**Rezoning Transportation Analysis**  
**Petition Number: Insert Zoning Petition #2021-214**  
*General Location Identifier: 11123345*

Date	Description
01-21-2022	First Review (AO)
02-24-2022	Second Review (AO)

**Transportation Summary**

SCHEMATIC SITE PLAN

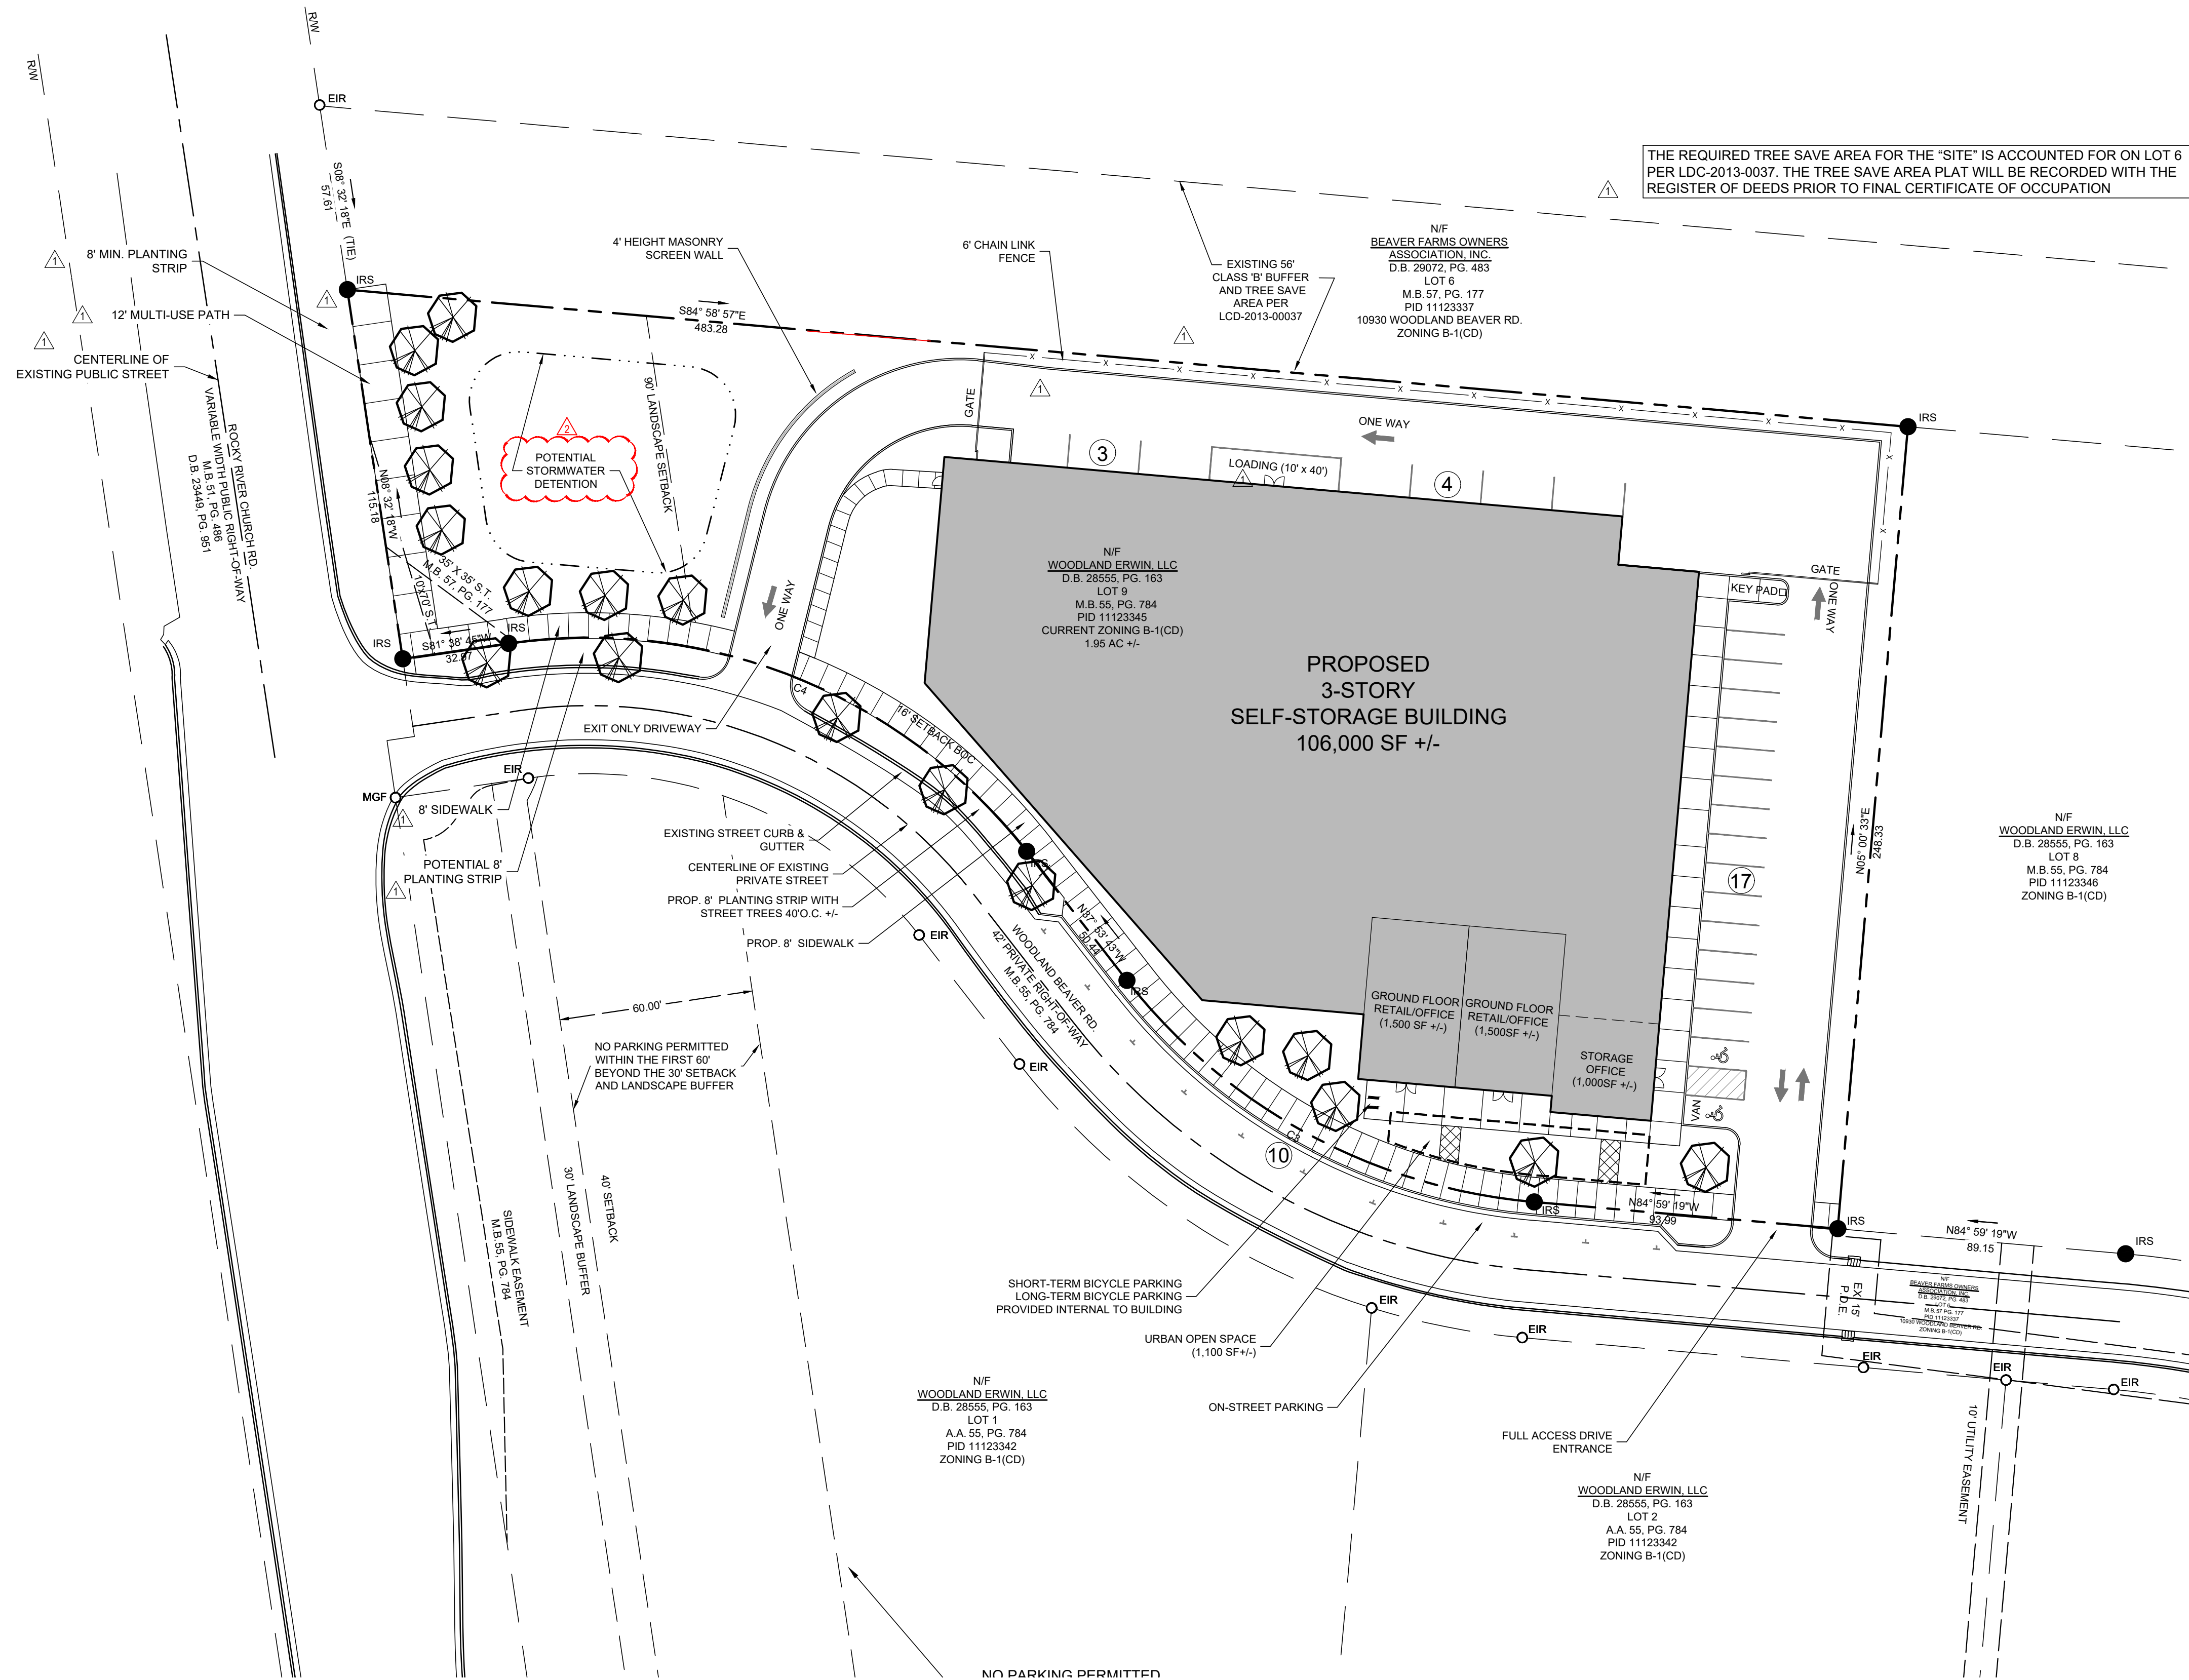
4. ~~Resolved (New Site Plan, 2-14-22):~~ Revise site plan and conditional notes showing a minimum of 100' of separation from proposed egress access point of Woodland Beaver Road measured from right of way line from Rocky River Church Road.

Label and dimension from right of way line along Rocky River Church Road.
